Mattamy Homes Richmond Official Plan Application
Response to City of Ottawa June 8, 2009 Technical Circulation & Additional Comments
March 10, 2010

DRAWING No: 6

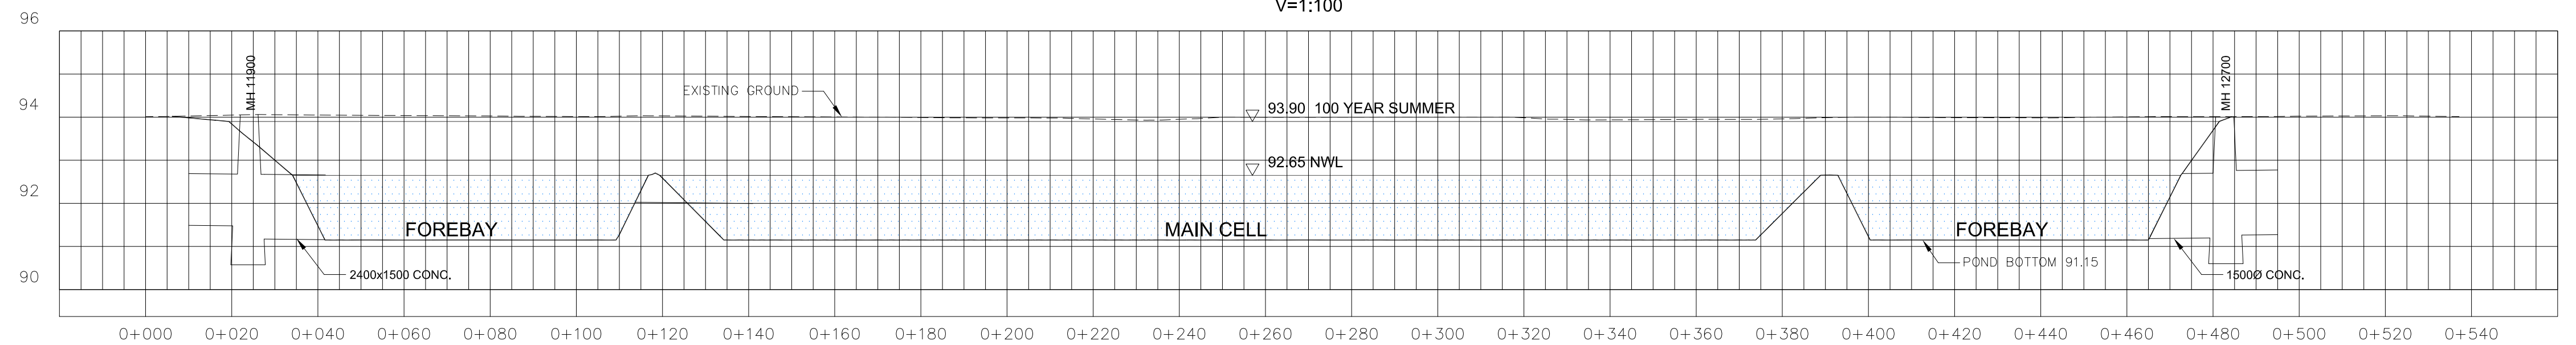
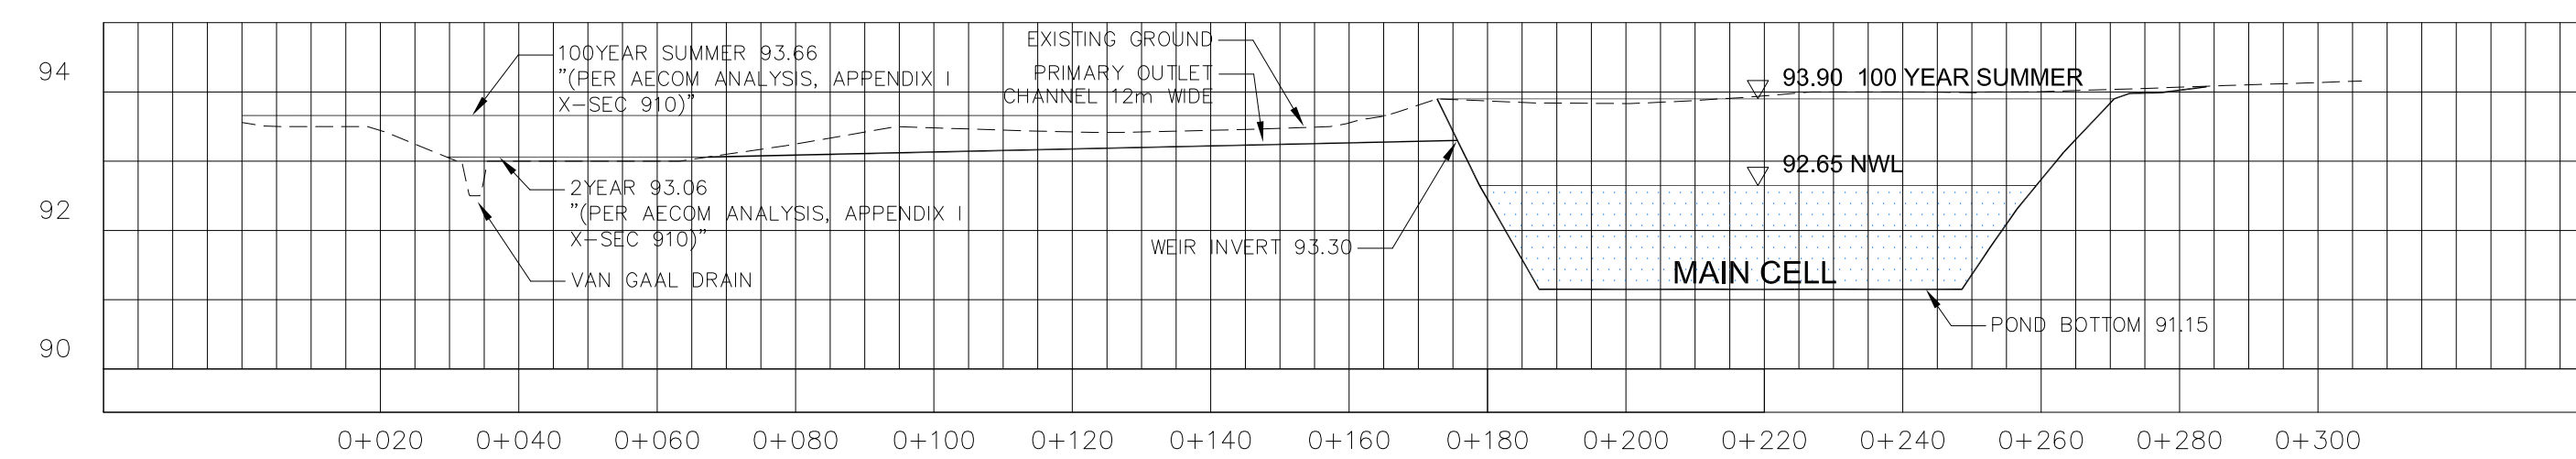
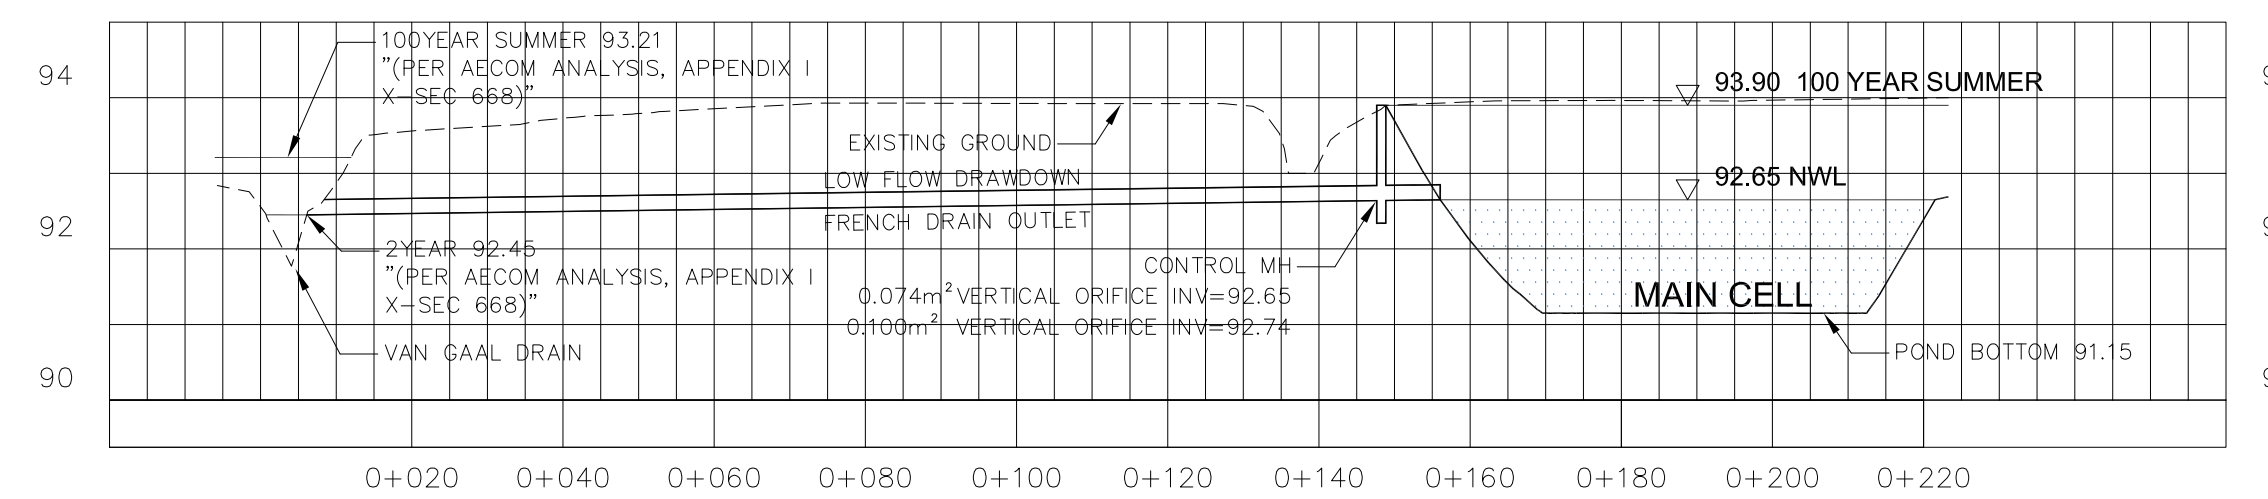
#	Comment	From	Date	Mattamy Response	Action Taken
	<p>achieve the proposed storage volumes: the top of the active level storage is noted as 94.10m (see Drawings 5, 6, 7) which is equivalent to the 100 yr flood elevation. However, the footprint of the proposed facility within the floodplain shows existing grades as low as 93.4m. As currently proposed, this would require a considerable amount of filling within the regulatory floodplain - which is not acceptable as it represents a loss of flood storage - most particularly given flood susceptible existing development downstream. There has also been no effort to indicate whether the outfall invert elevation is located above the 2 year flood elevation.</p>

PROJECT No.: 07-303  
DATE: 2010-03-10  
DRAWN BY: SK  
SCALE  
DRAWING No: 7

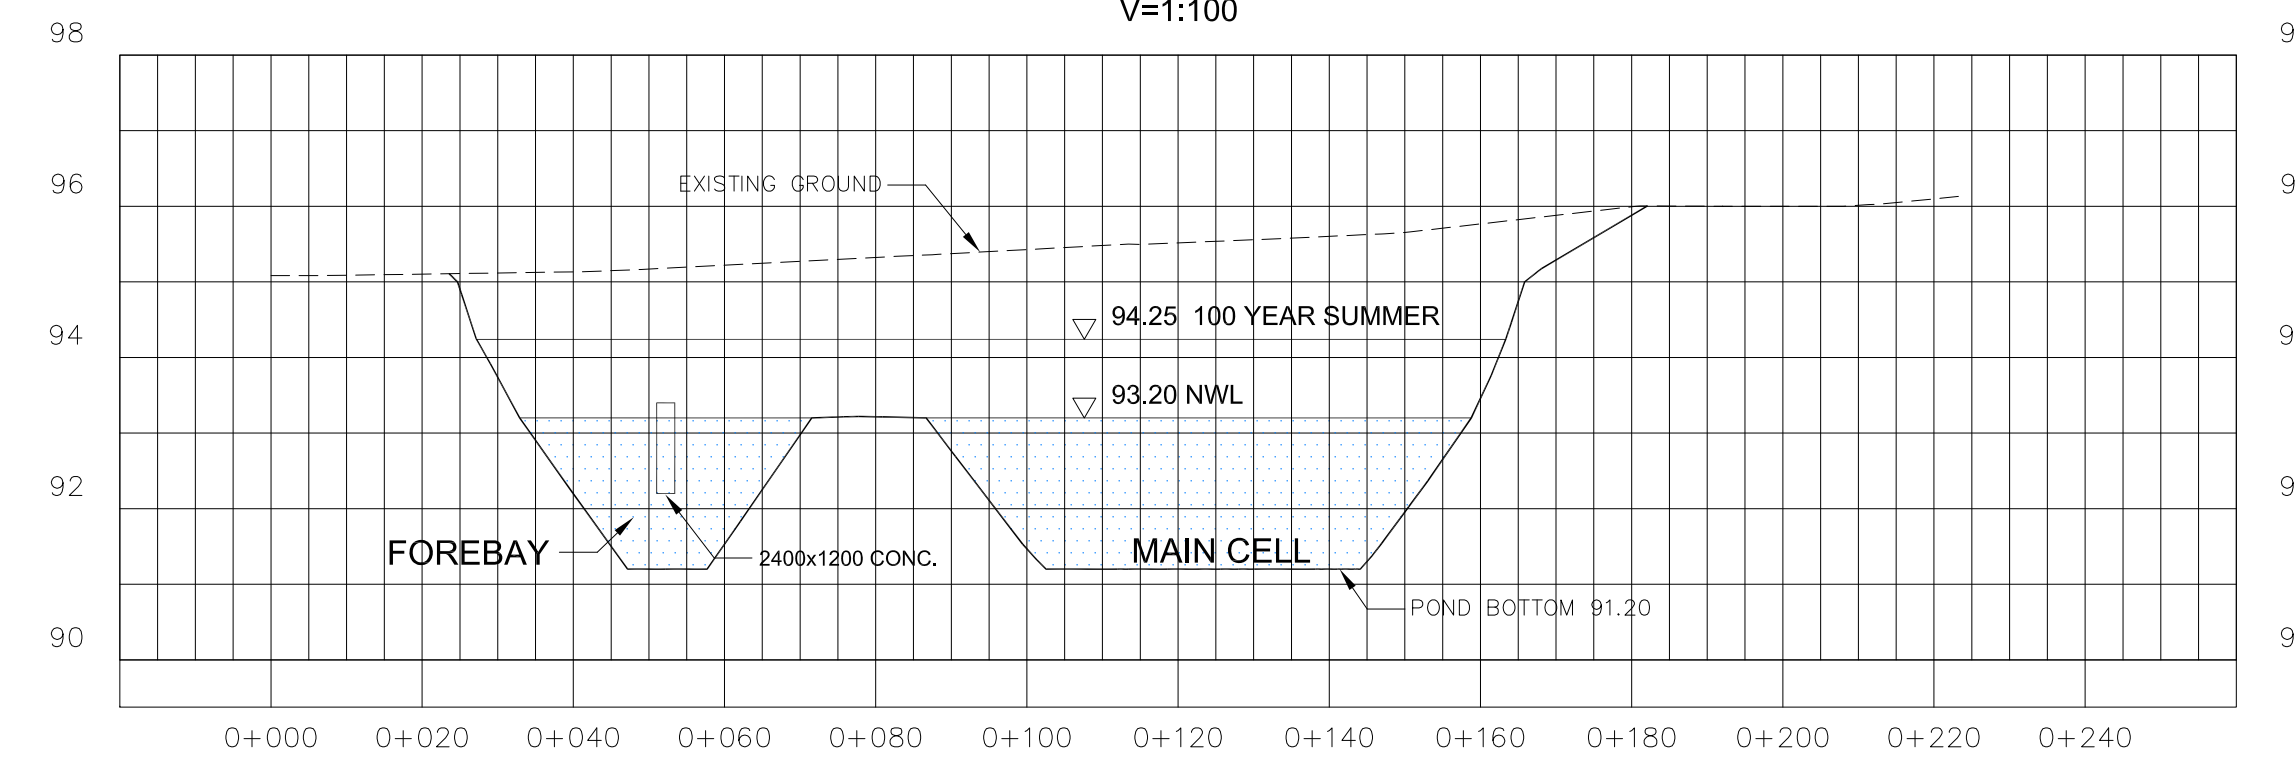
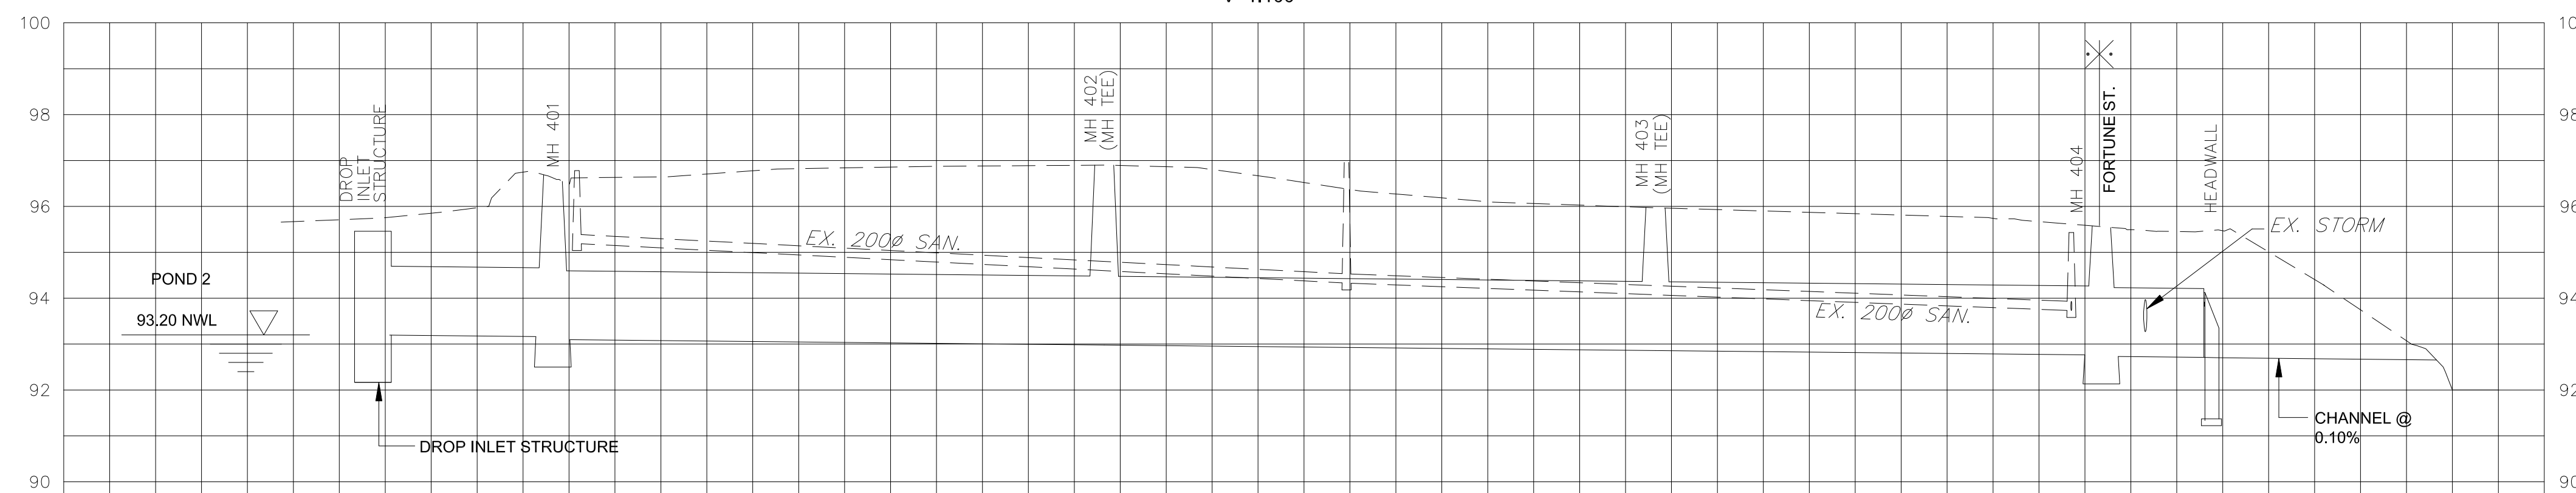
49.	<p><u>Drawings:</u></p> <p>Dwg 7: Label external drainage areas to be conveyed through site (hectares). How are major system flows to be conveyed across Perth St.? How are major system flows (that need to be controlled to pre-development levels) to be conveyed across the open channel to Pond 1? and across Ottawa St. to Pond 2?</p> <p>Dwg 8: What is the source of the normal water level in the Van Gaal drain (93.0m)? Please confirm.</p> <p>Dwg 9: Are there any conflicts with existing sanitary laterals? If yes, how is this to be addressed?</p> <p>Grading plans should indicate both existing and proposed grades and provide existing contours.</p>	City – Infrastructure Planning	January 29, 2010	<p>Drawing 7 – Relevant drawing have labeled the external drainage areas. The major flows across Perth Street will be conveyed through trunk storm sewers.</p> <p>Drawing 8 – Water elevations has been updated per AECOM Fortune Street Culvert Analysis.</p> <p>Drawing 9 – No service lateral conflicts exist based on available information. Detailed Drawing 1 contains existing and proposed grades.</p>	Report and Drawings updated accordingly.
